From: Steven King [REDACTED]
Sent: 10 October 2022 13:28
To: Connor Smalls [REDACTED]
Subject: Re: 22/01559/F The Maltings, Tower Road, Burnham Overy Staithe.

Steven
Steven King
Conservation Officer
Borough Council of King's Lynn and West Norfolk
[REDACTED]

Dwg: 1.05
Rev: 04

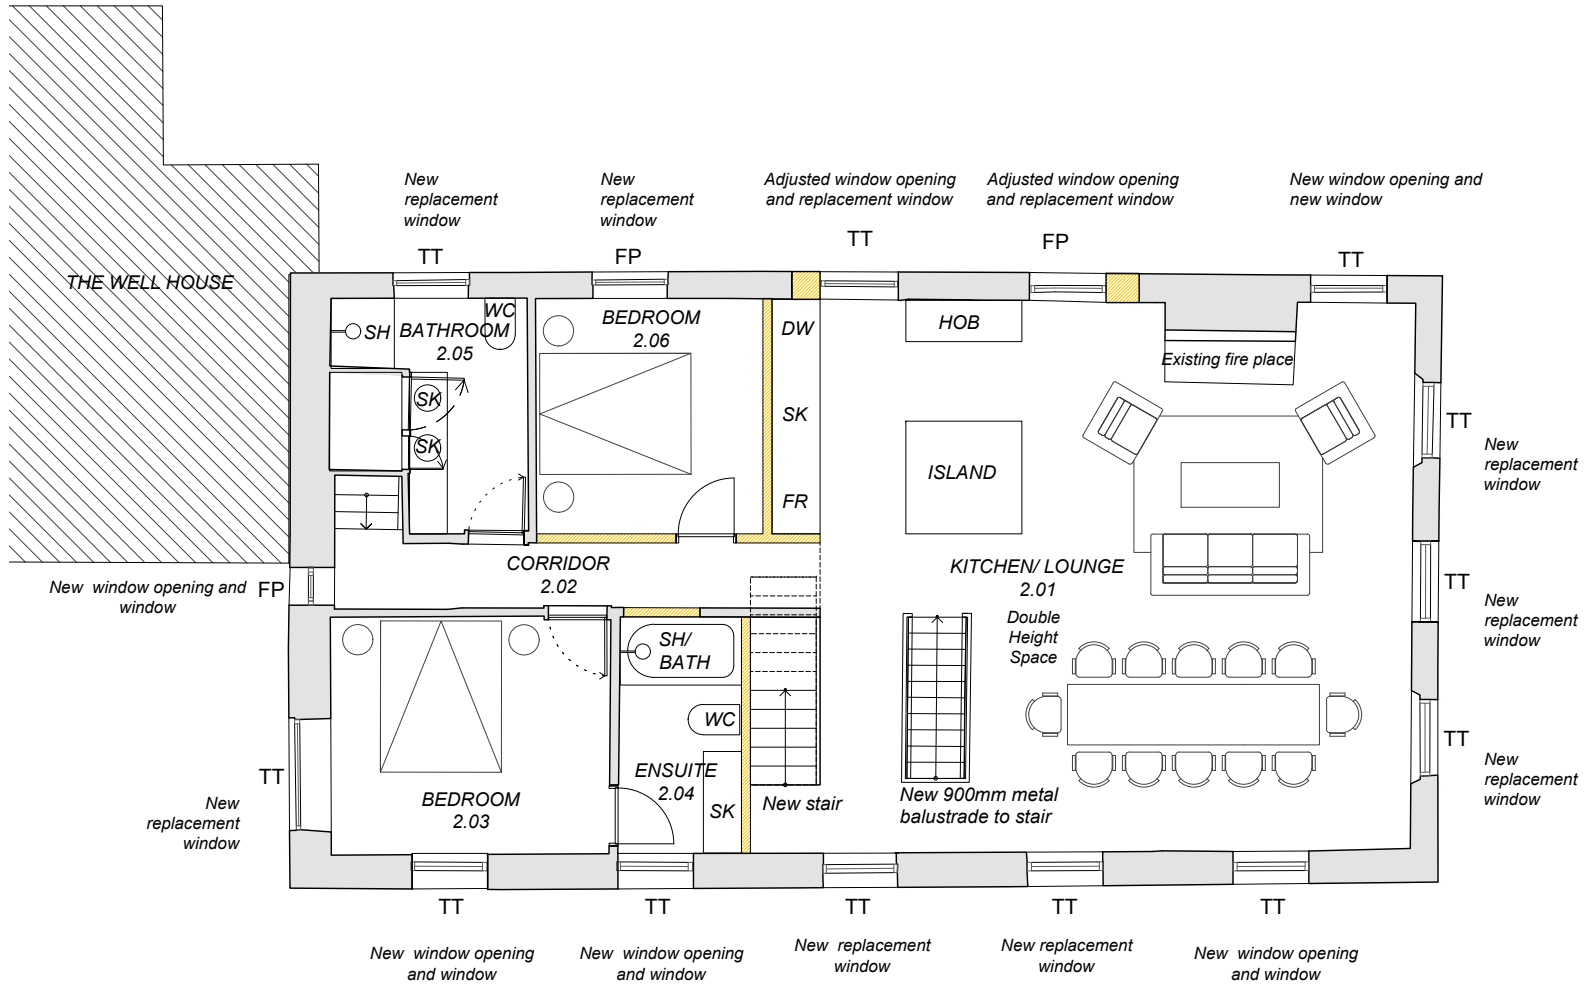
Window treatment to north and west elevations
Given the existing treatment well designed aluminium windows may be acceptable. However, I am still not convinced by the window styles to the north and west elevations. In the current form the windows look blank and featureless, unlike other windows in the locality. Some introduction of glazing bar would help along with more confirmation that the windows are to be recessed within the masonry.
